Planning Services Sign Permit Review Form

Date of Submittal	Application Number	Applicant	Landowner
6/17/2022 Revised Plans 7/29/22	SIGN2206-0002	Post Nursery	DRB Group

Contact Person	Post Nursery	Contact Number	(919) 554-4002
Sign Location	NC 210 N & Hayfield Drive	PIN Number	0662-10-5154.000

DAN RYAN BUILDERS
THE FARM @ NEILLS CREEK
DIMENSIONAL DETAILS

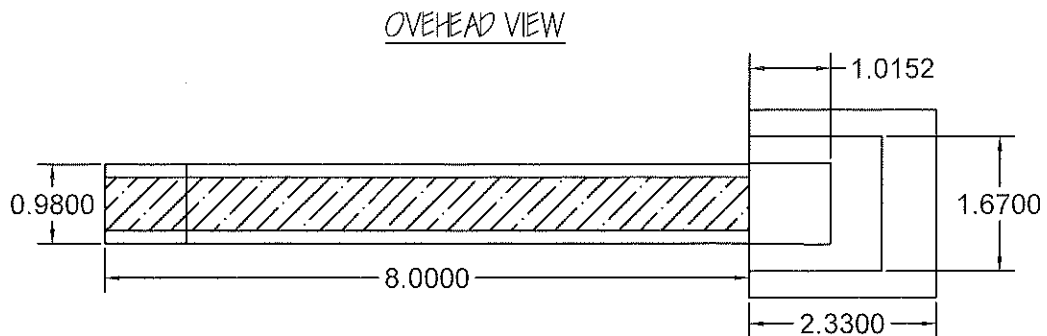
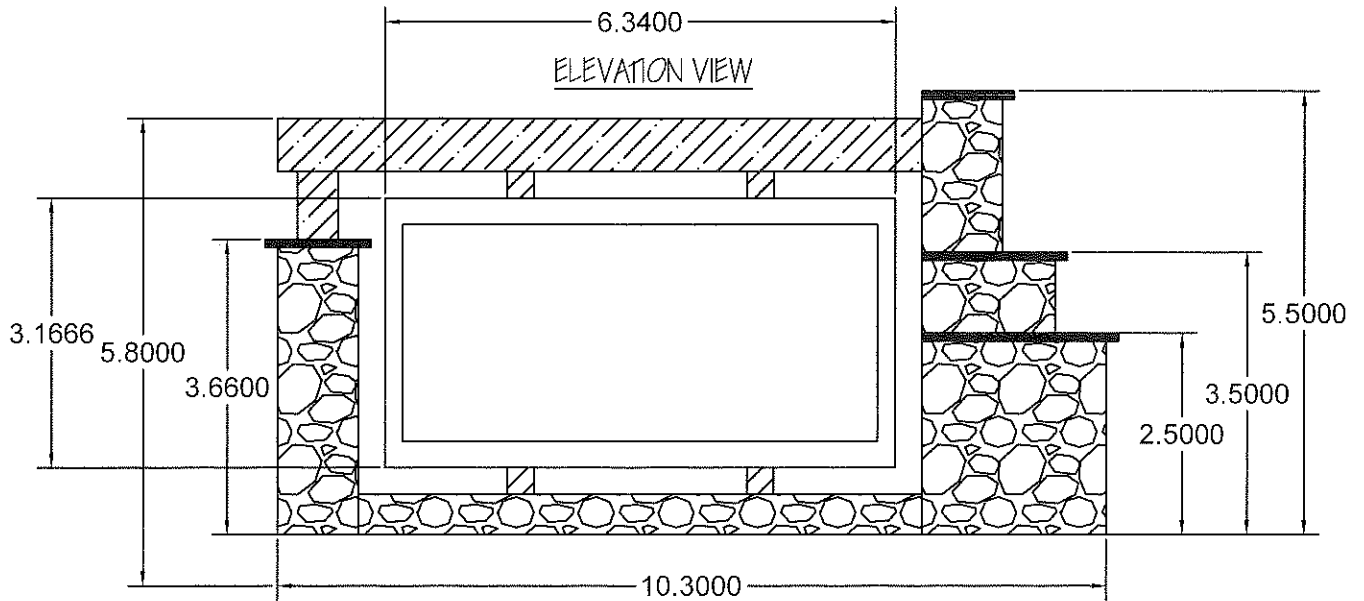
Comments	See the site plan and updated measurements below.
